THE NEW SYDNEY FISH MARKET AT BLACKWATTLE BAY SSD 18_8924 and SSD 18_8925 MOD 1 RESPONSE TO SUBMISSIONS

Prepared for
Infrastructure NSW

By
BBC Consulting Planners

February 2021

**Diagram : Proposed Relocation Of Rowing Route**

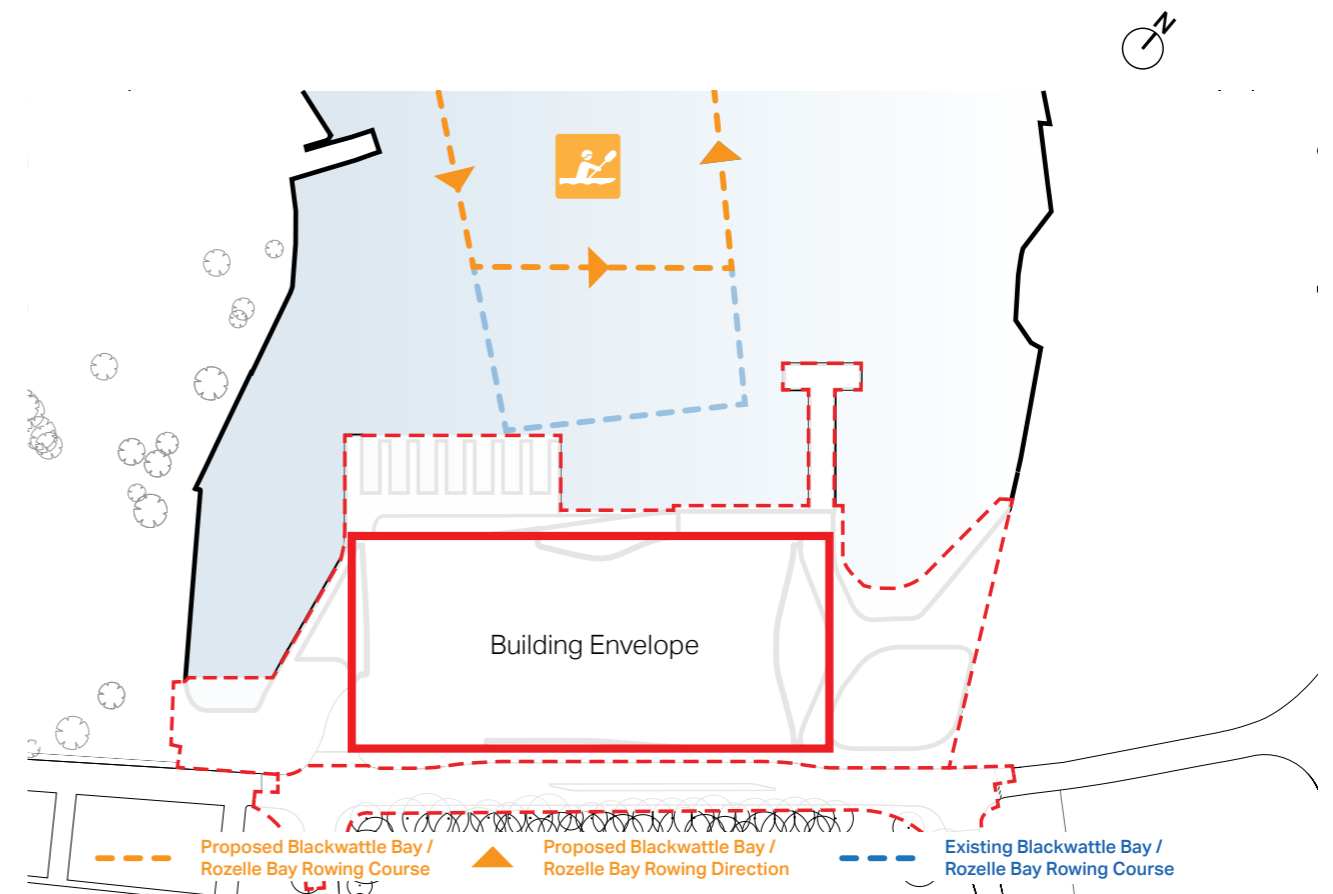
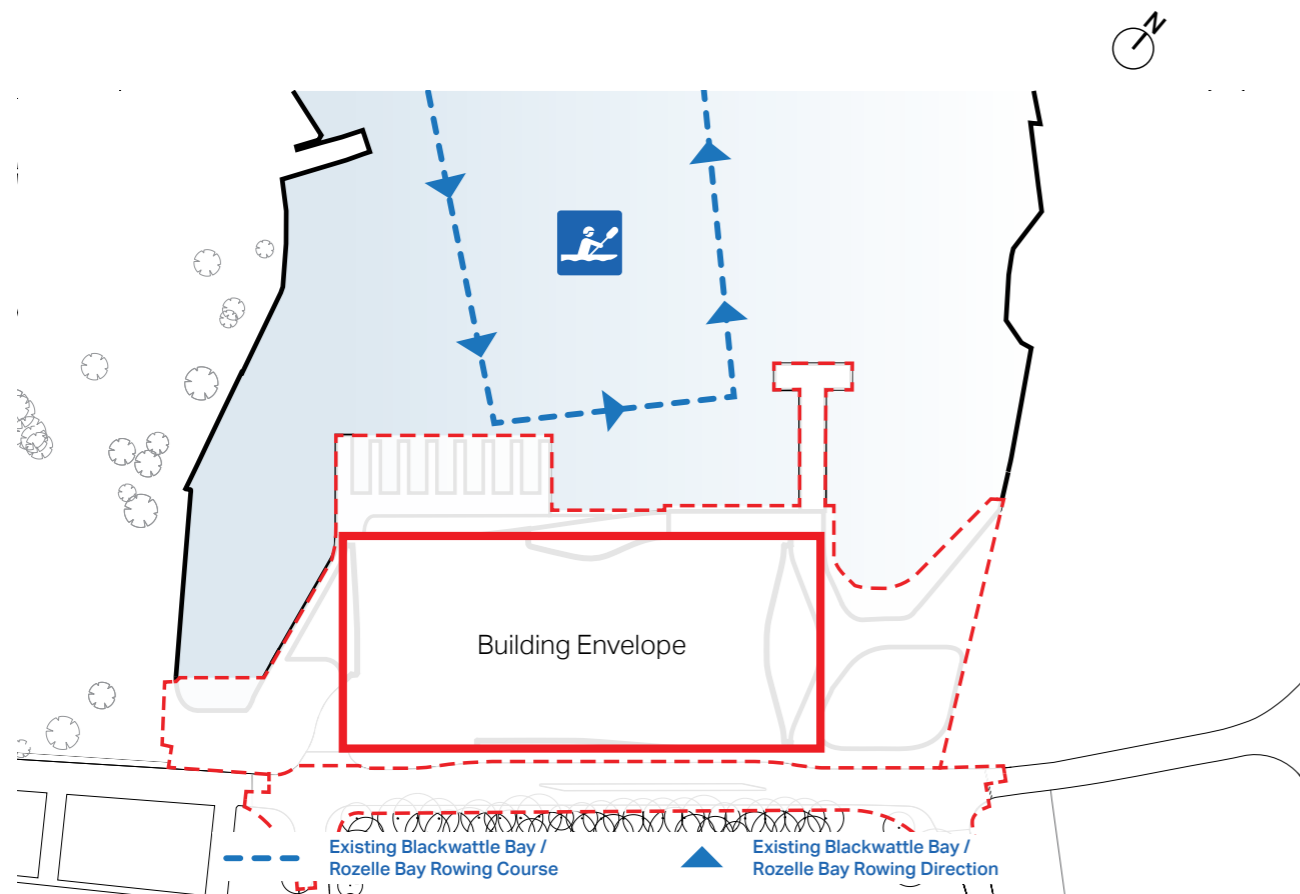
Department of Planning, Industry and Environment	Impact on Rowing Clubs	It appears the modification to the recreational wharf will result in shortening the length of the rowing route at the head of Blackwattle Bay when compared to the approved development (Figure 1). Further discussion on this aspect of the proposal shall be provided within the modification report including justification for the shortening of the rowing route and its potential impact on rowing clubs.	The rowing course was modified to be 45m clear of the new wharf position which was moved further west. The head of the proposed wharf is the site of a potential ferry wharf and would be subject to turning manoeuvres as the ferries move in and out of berth. As such, it is important that the rowing route is kept clear of this manoeuvring area. The basis of the original rowing route was that the route was kept 45m from wharves at the head of Blackwattle Bay (including the former Fish Market trawler wharves and Blackwattle Bay Marina). RHDHV have applied the same principal in determining the offset from the proposed wharves. The relocated rowing route has the effect of reducing the length of the rowing route by 60m on each side of Blackwattle Bay from its original length of c. 3100m. The previous revision showed a reduction of 48m on each side of the rowing route, a difference of 12m from approved SSDA route. This modification to the rowing course was issued to the rowing and dragon boat clubs. No concerns were raised.
